November 09, 2022

Subject: Shoreline Exemption Permit (SX-22-00021 Sporar) – Request for Additional Information

<b>FEMA BASED ZONE MAP</b>		
PREPARED FOR <b>MR. TOM SPORAR</b>		
KITTITAS COUNTY,	DATE	RSN NO.
OWN BY <b>AGJ</b>	<b>12/07</b>	<b>07178</b>
DRAWN BY <b>R. BOGDON</b>	SCALE <b>1"=20'</b>	SHEET <b>1 of 1</b>

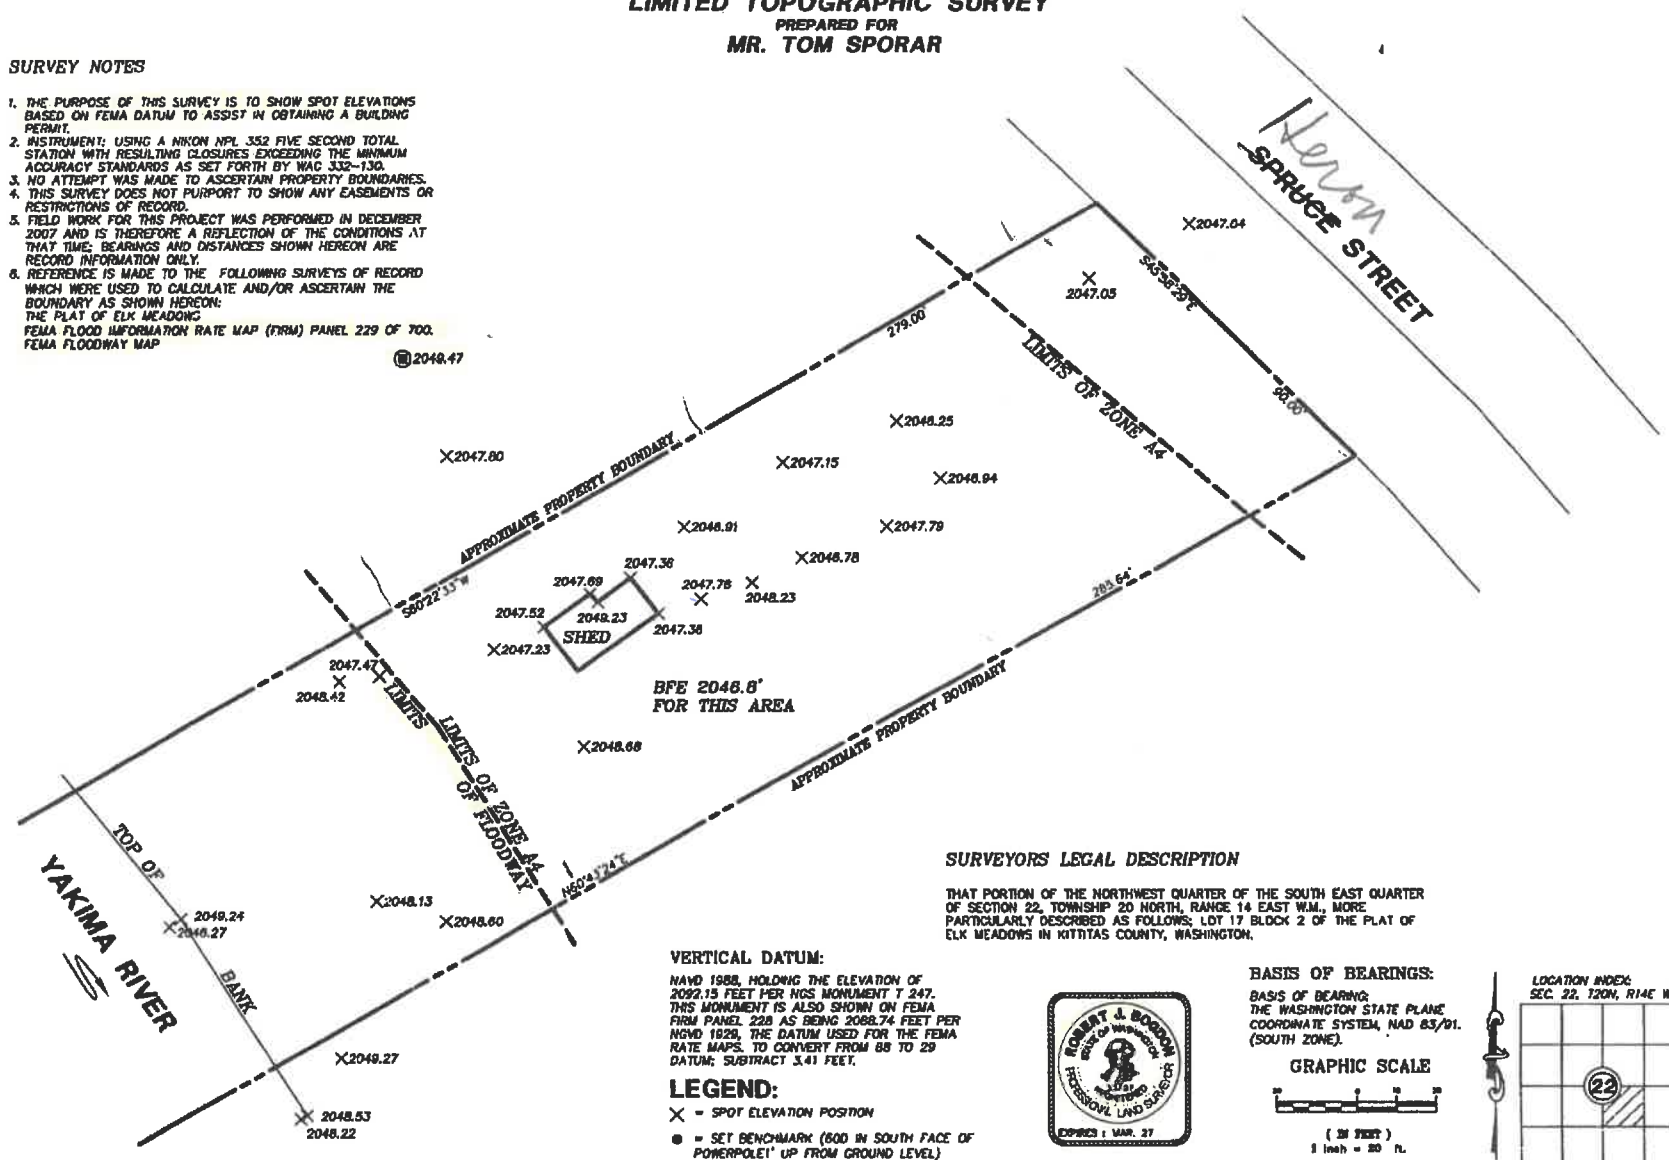
1. Please provide an updated survey, to be completed by a licensed surveyor, which marks the floodway boundary on the subject parcel. The structure cannot encroach upon any portion of the floodway boundary.
2. Please update the site plan with floodway boundary information and show distance from structure to floodway boundary.
